# Bramford to Twinstead Reinforcement

Document 8.12.2: Applicant's Comments on Other Submissions Received at Deadline 9

Final Issue A  
March 2024

Planning Inspectorate Reference: EN020002

Drawing title
**F-AP4: B1068 Stoke Road, Leavenheat
 Proposed Visibility Splay
 Concept Design
 Sheet 1 of 1**

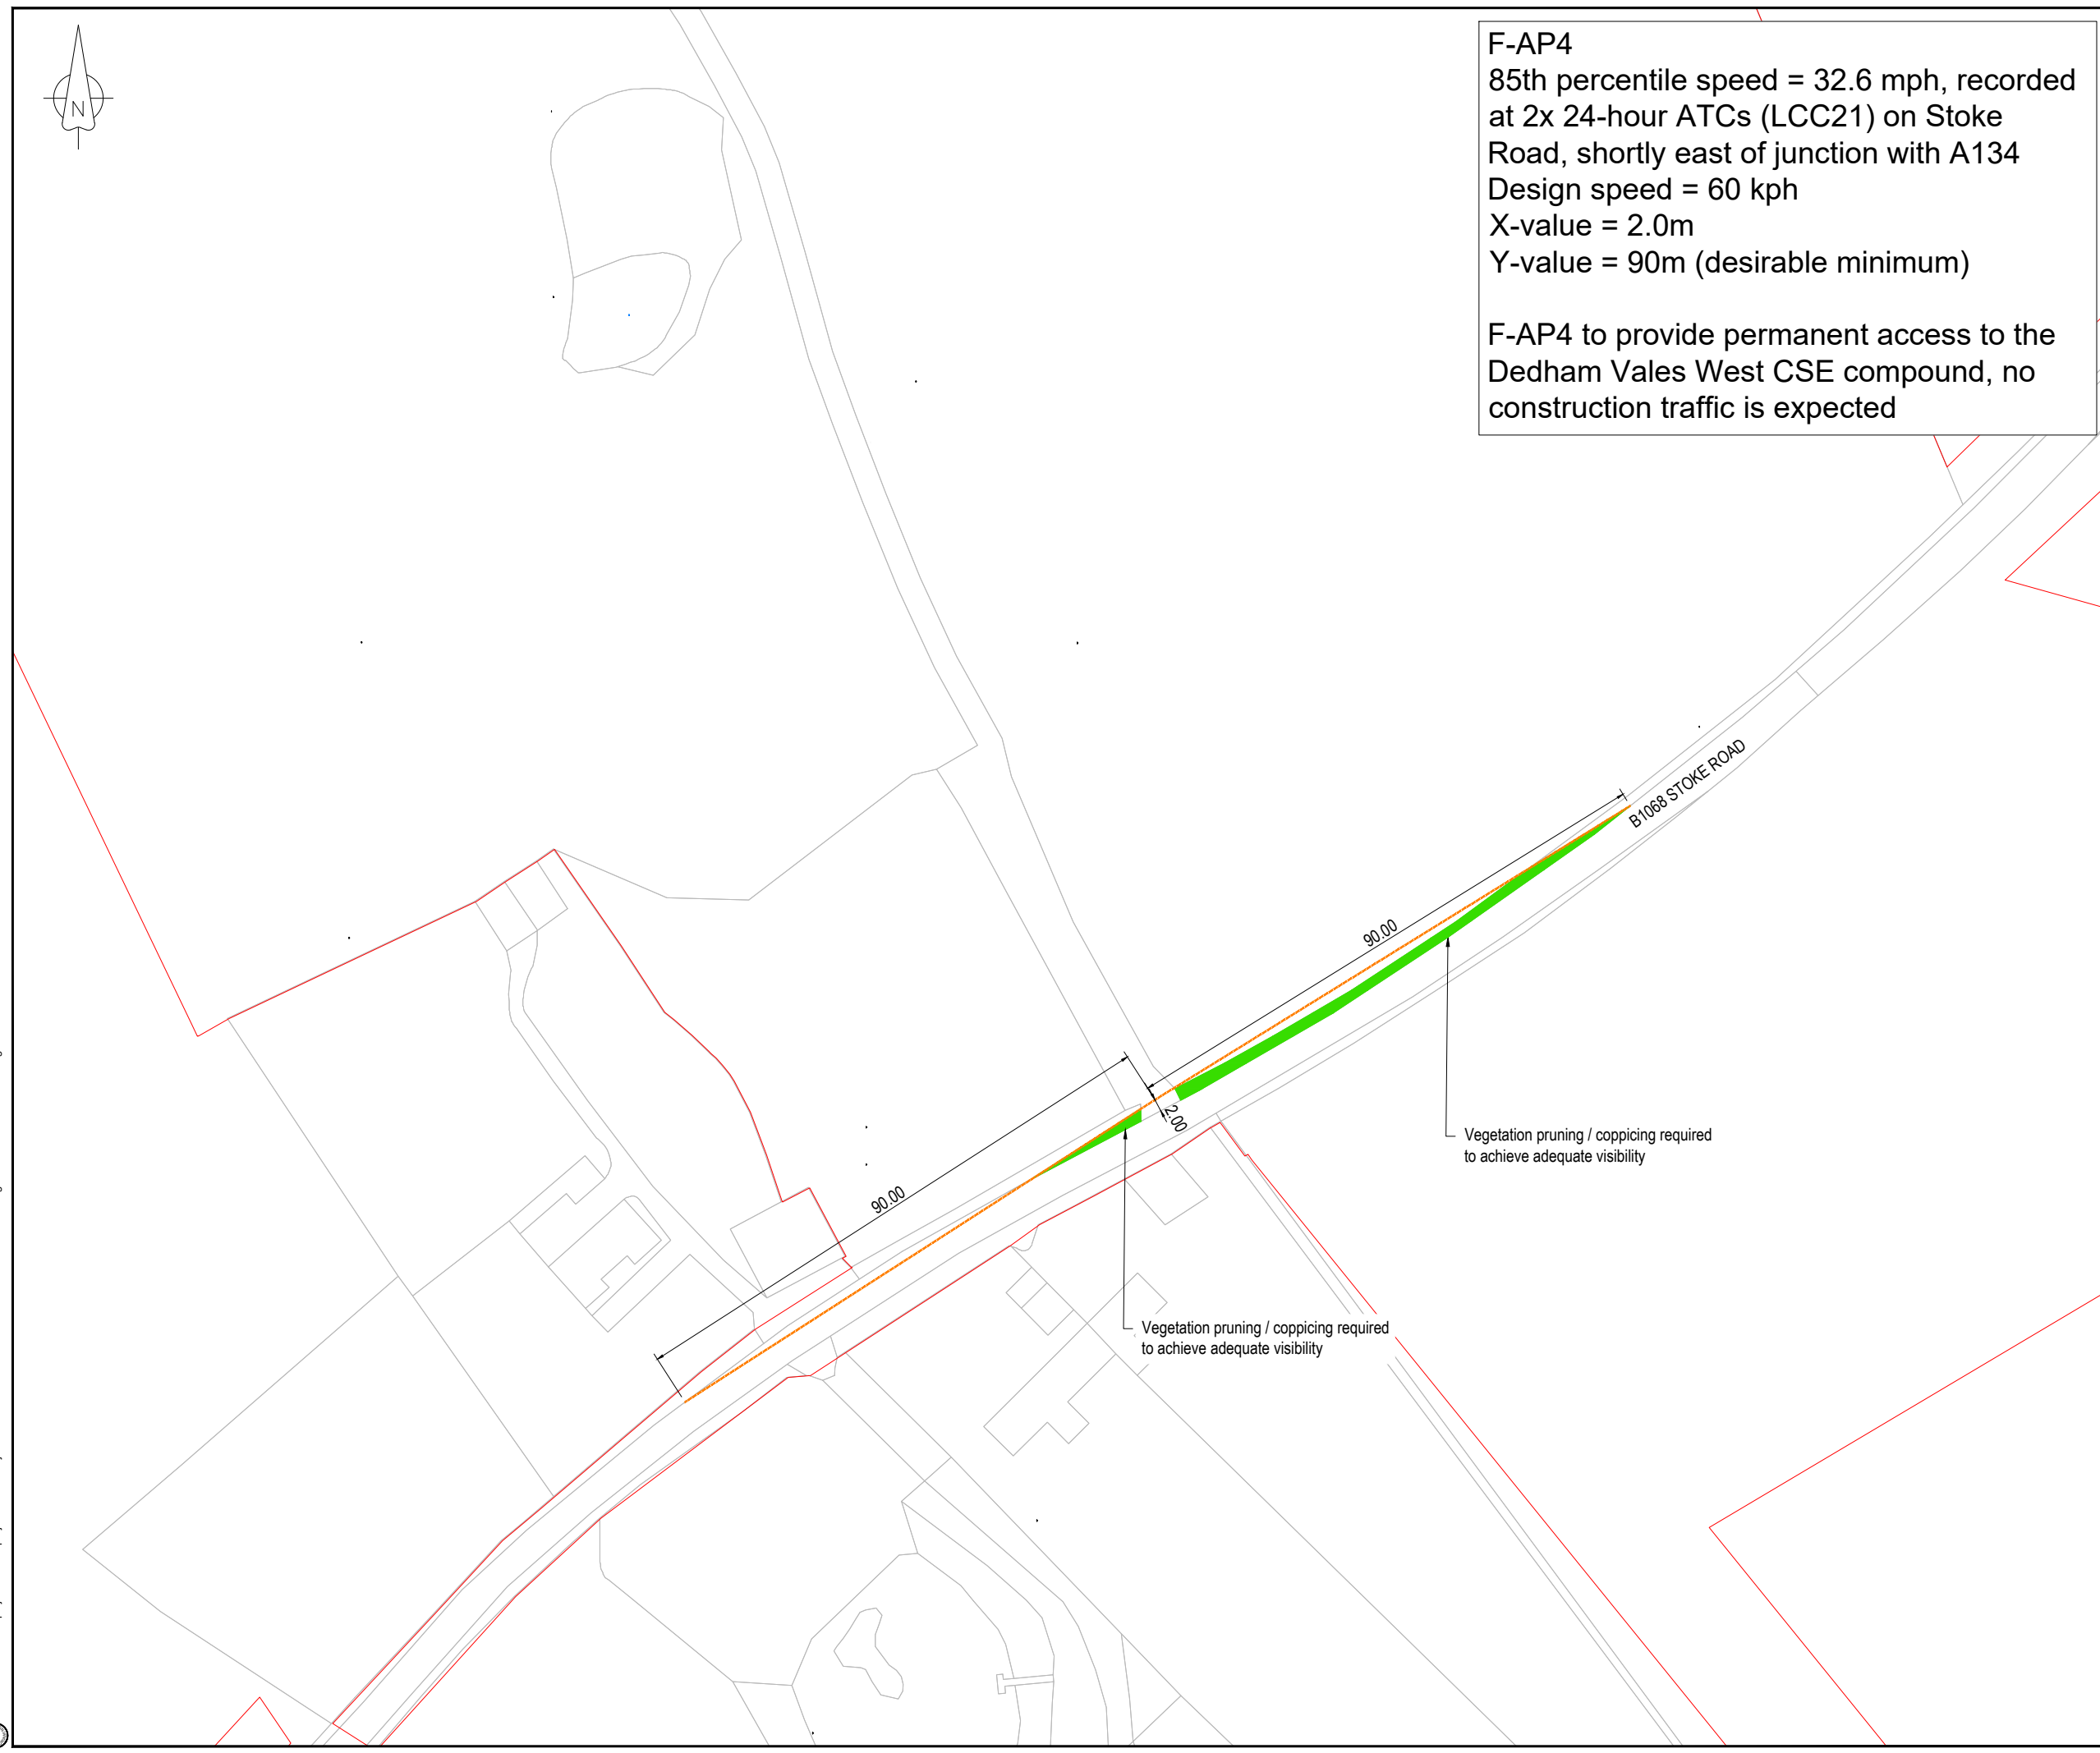
1c-1e	Specific comments on access points:	SCC has provided specific comments on access points:	See the response to 1a above in relation to new access points being requested for further assessment.

- D-DAP2 Millwood Road (Access to Dedham Vale East CSE compound);
- AP4 Stoke Road, Leavenheath (Access to Dedham Vale West CSE compound);
- G-AP3: B1508 Bures Road, Sudbury (Access to Stour Valley East CSE compound).

SCC considers that, when the changes in reinstatement and mitigation planting will be made, a placemaking approach will be required and new hedgelines (and trees) should be provided on either side of the access, in such a way that they will accommodate the required visibility splays, while delivering adequate mitigation.

If during the detailed design, the vegetation removal and reinstatement would be different to what is currently assumed, then updated versions of LEMP A: Retention and Removal Plan [REP9-040] and LEMP B: Reinstatement Plan [REP9-041] would be submitted in accordance with Requirement 8 and 9 of the draft DCO [REP9-006].
